BUILDING CODE OF AUSTRALIA 2019 FINAL REPORT FOR SSDA SUBMISSION

PROPOSED INDUSTRIAL DEVELOPMENT AT 57 TATTERSALL ROAD, KINGS PARK NSW 2148 'PICK N PAY LESS CAR YARD – STATE SIGNIFICANT DEVELOPMENT APPLICATION (SSDA)'

Report Ref: 18-210813_AutoRecyclers_57Tattersall_SSDA_FinalBCA2019-
Rprt_R04_07082019

Date: 07 August 2019

NOTE : BUILDINGS BC + D TO HAVE AUTOMATIC SPRINKLER SYSTEM

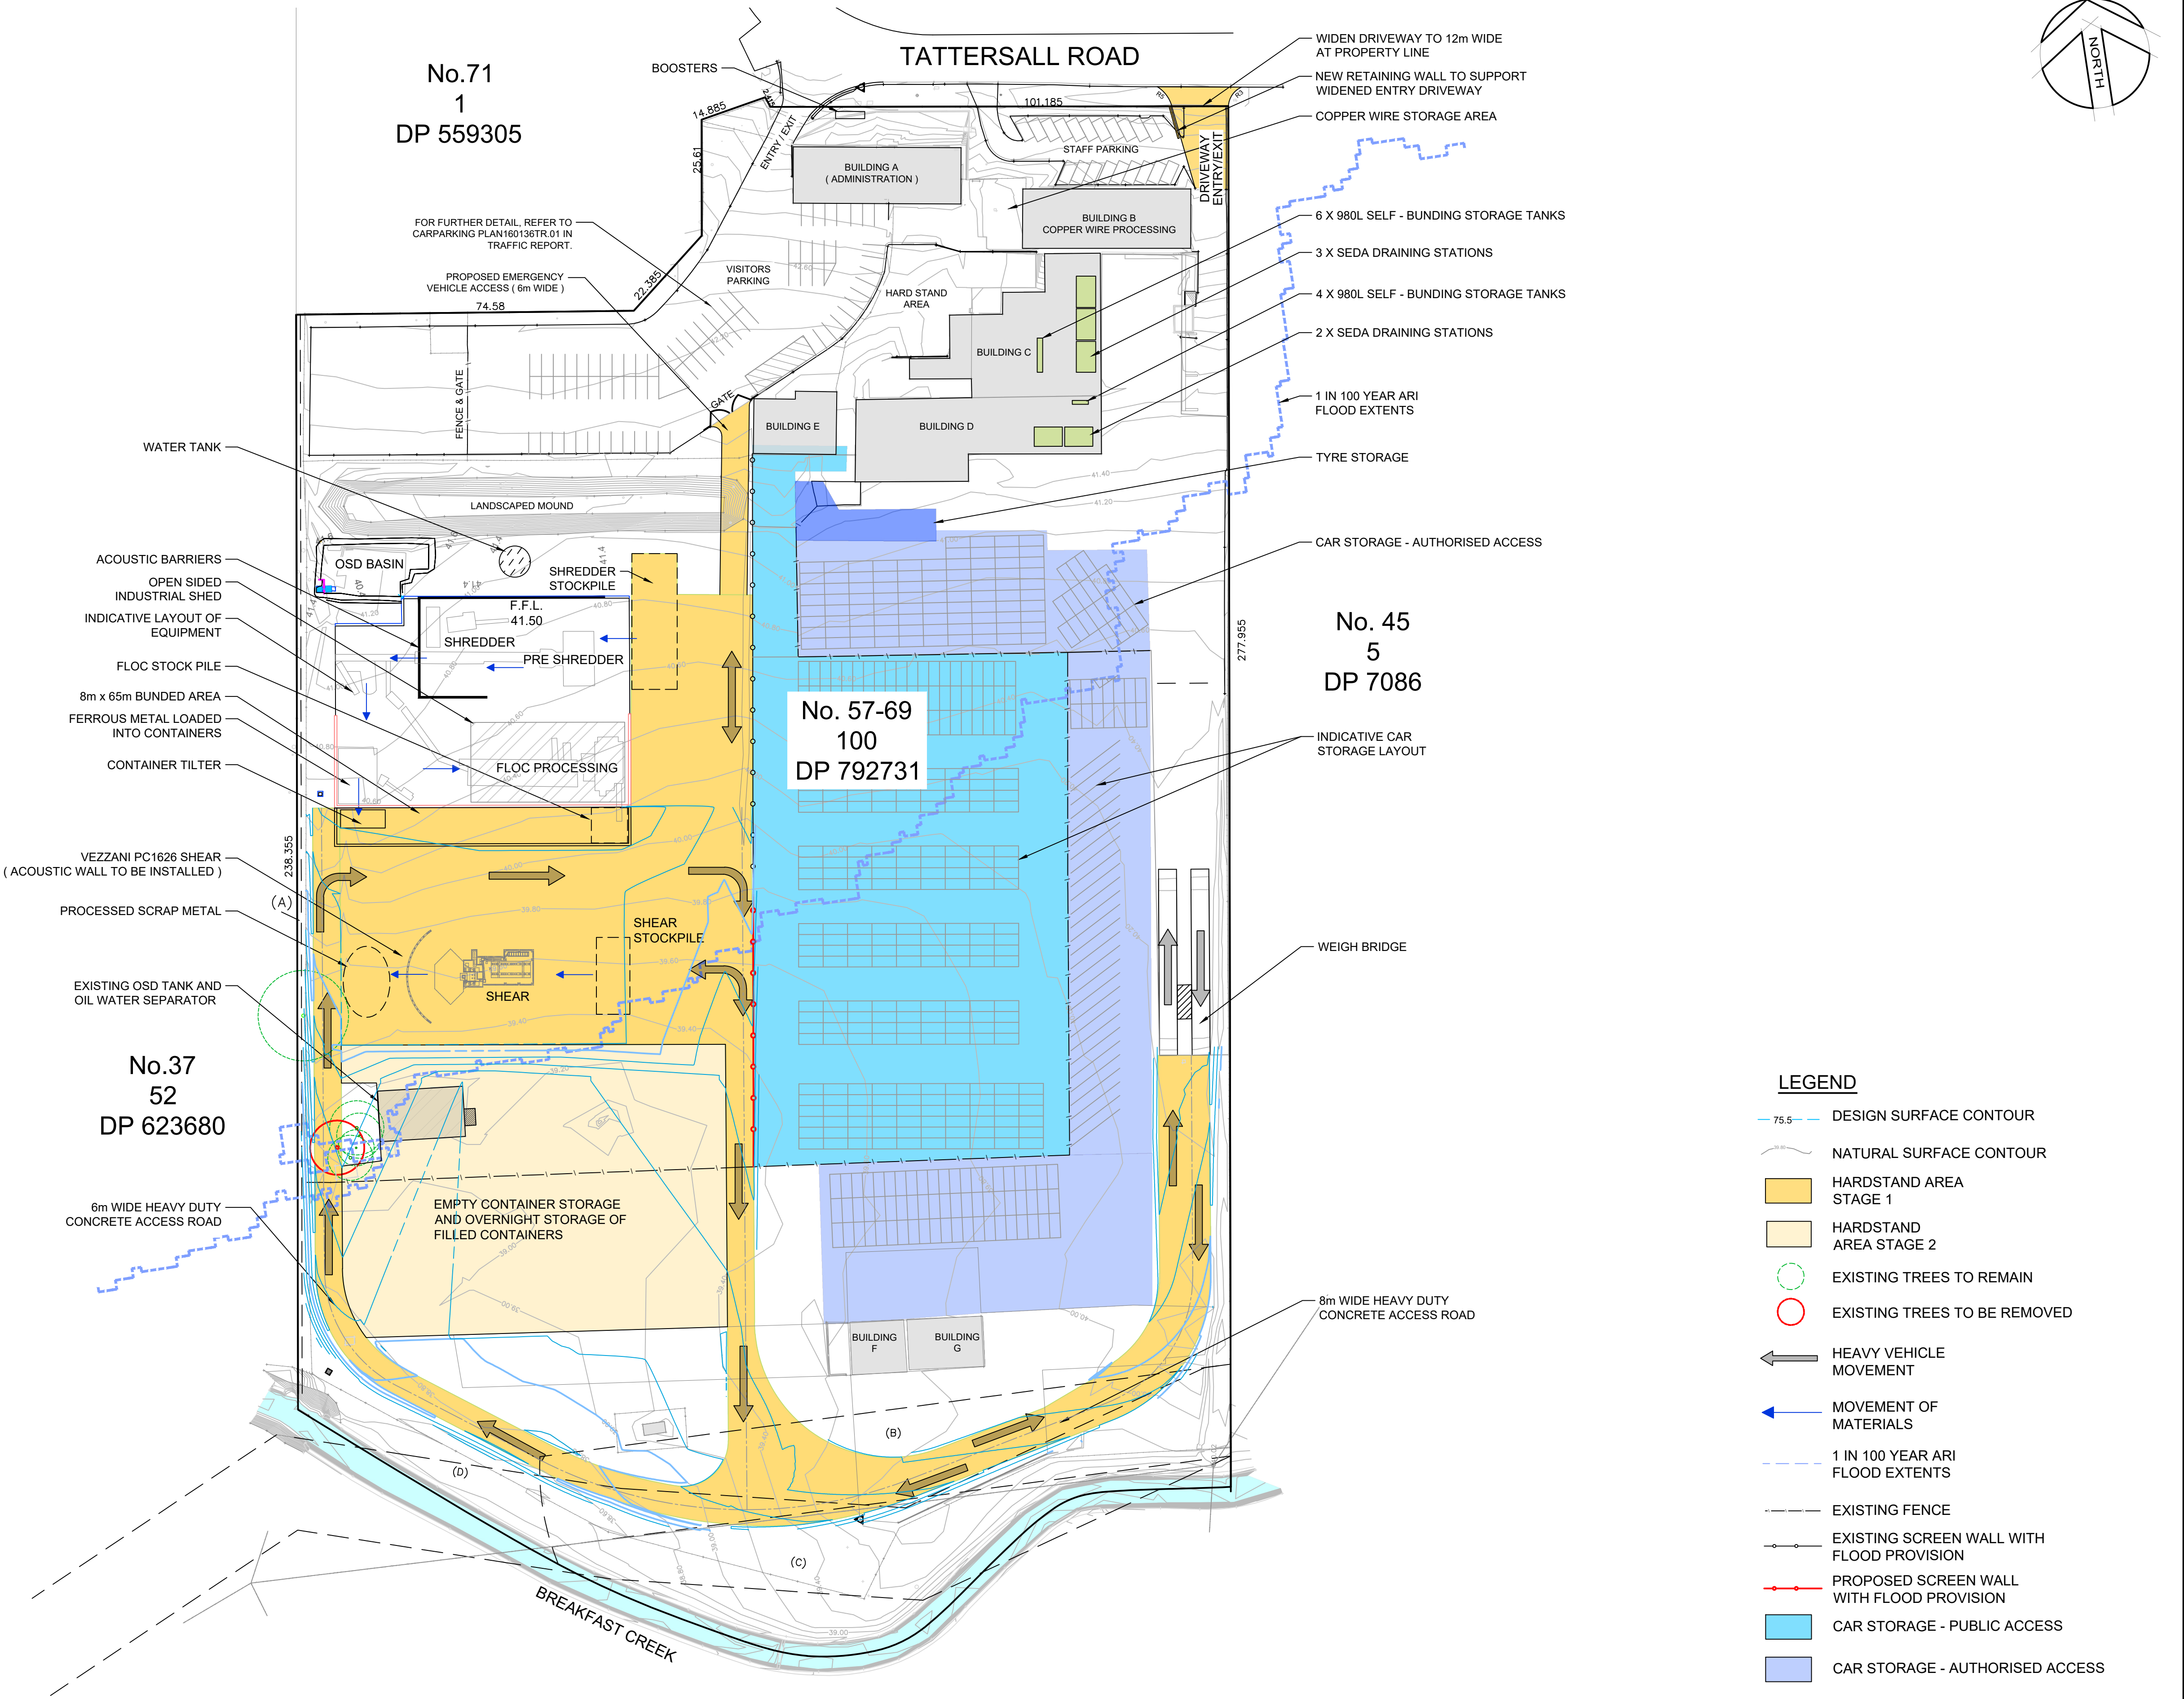
20. **Sprinklers (E1.5)** – Buildings B, C and D are United hence the building is deemed a large-isolated building requiring sprinkler protection as per Clause C2.3, C2.4 and E1.5 of the BCA. In addition, the building is considered ‘occupancies of excessive hazard’ with a fire compartment of more than 2,000m² and therefore required to be provided with sprinkler system complying with Specification E1.5. ***It is understood that a sprinkler system will be provided to building B, C and D – Wet Fire consultant to provide details at CC stage for Assessment. It also understood provision for sprinkler booster is also required.***

and D are considered occupancy of excessive hazard exceeding 2,000m² in floor area. It is understood that a sprinkler system will be installed to the United Building. Red Fire to address Clause E1.10 and the recommendations of the FRNSW (see Appendix B).
